Application Ref: H22-0566-26

Proposal: **Erection of a free range egg laying unit including egg packing and storage building, feed silos and associated infrastructure**

Location: **Land east of Delgate Bank, Weston, Spalding**

Deferral: LCC is not currently in a position to support the application and requests further assessment, supporting evidence, revisions and/or dialogue, as set out in the response.

Title
Proposed Passing Places Preliminary Design and Artic HGV Swept Path Analysis

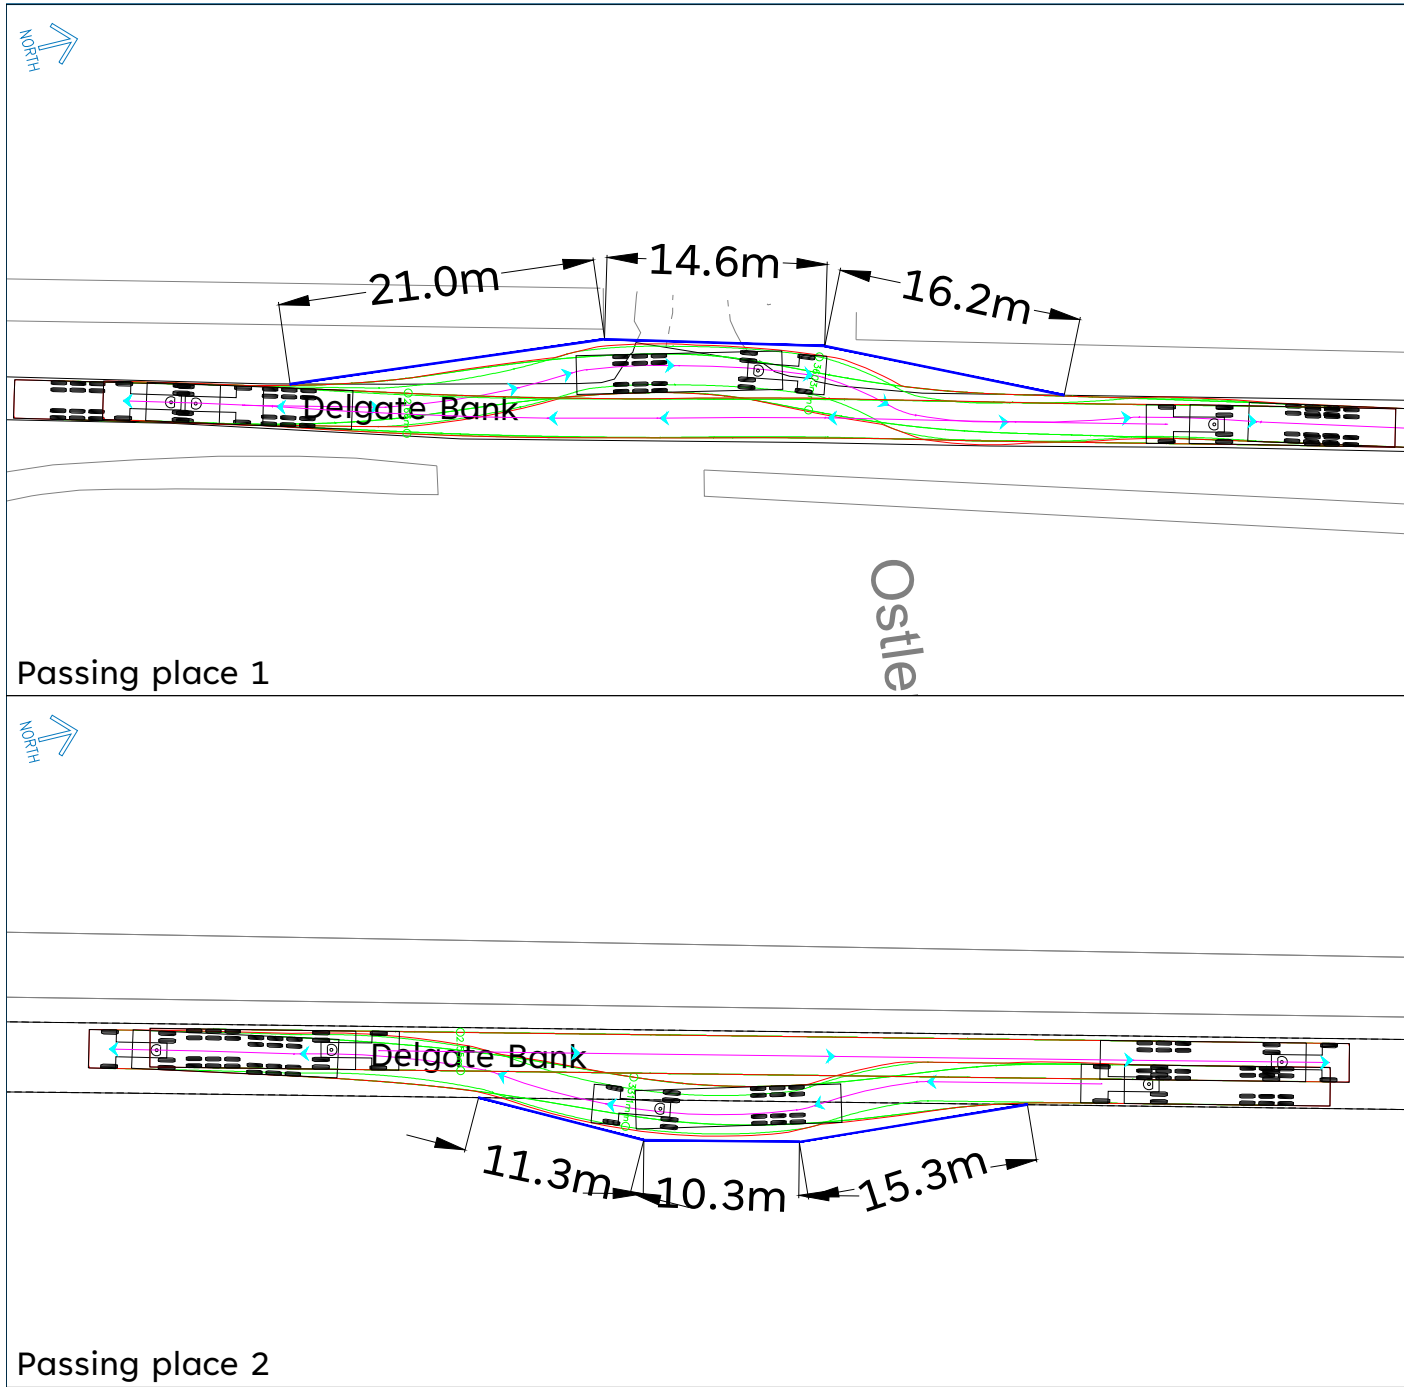
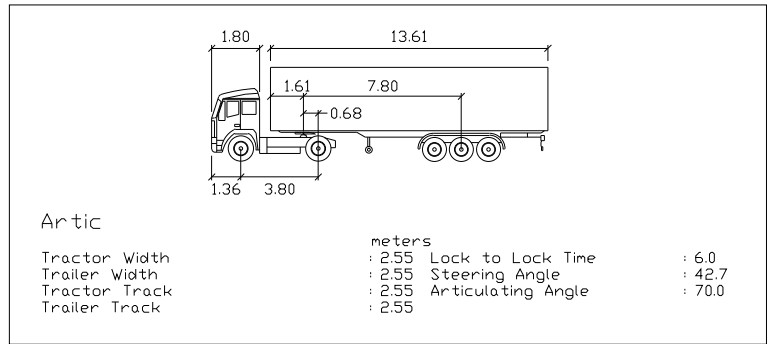
Delgate Bank is narrow in width. The applicant is to consider some appropriate mitigation for the increase in vehicular movements along Delgate Bank, in the form of minor widening or passing places large enough to allow 2 HGVs to pass.

Proposed Access Design - Scale 1 : 250

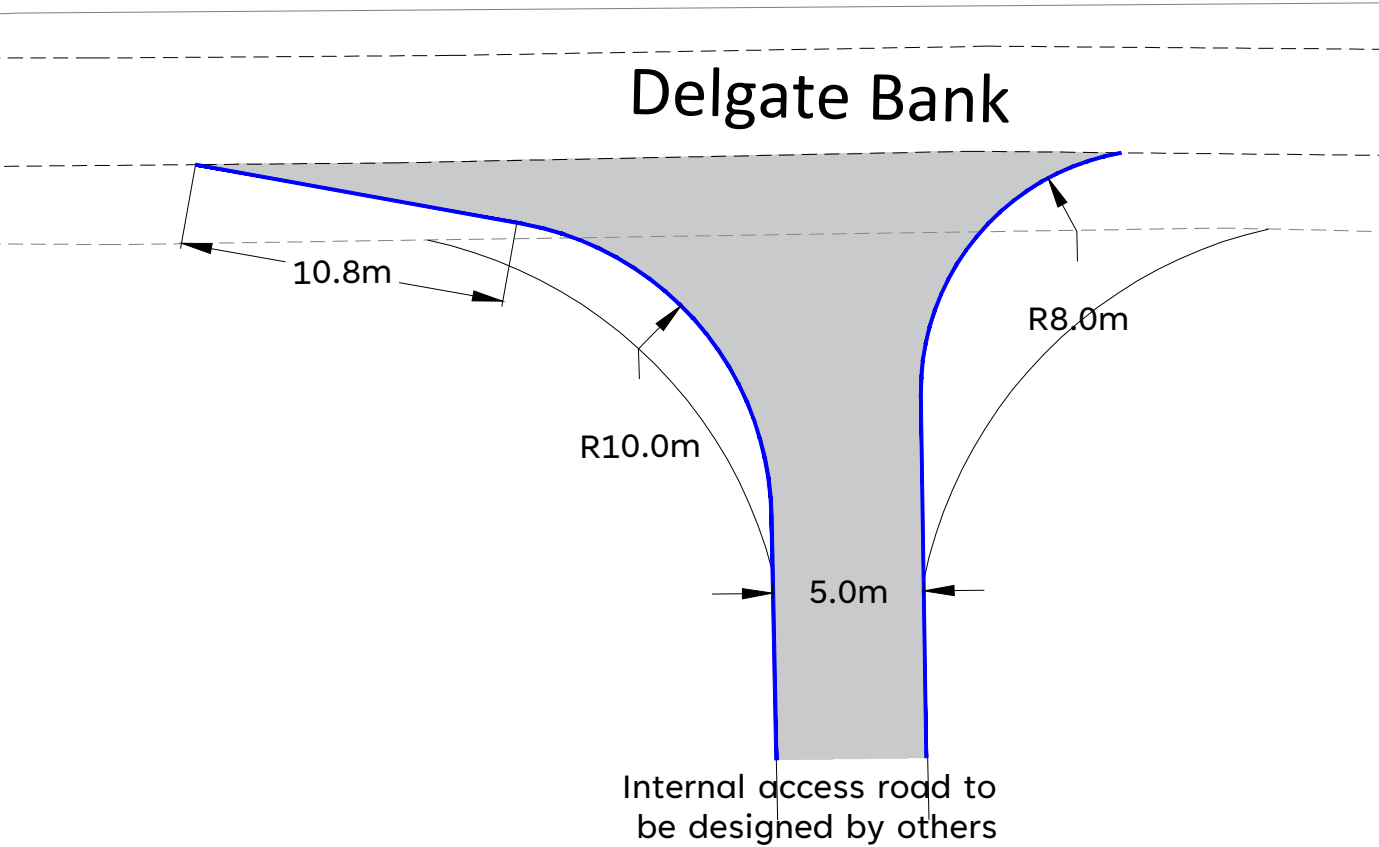
Development will require the improvement of the existing access to a bound material within the extents of the public highway. The Highway Authority would request that the applicant submit details demonstrating these access improvements. The specification and construction details for a standard light duty flexible dropped crossing can be obtained from the Highways Network Team on 01522 782070, or alternately the applicant can note on the drawing that the access will be constructed in accordance with the LCC specification.
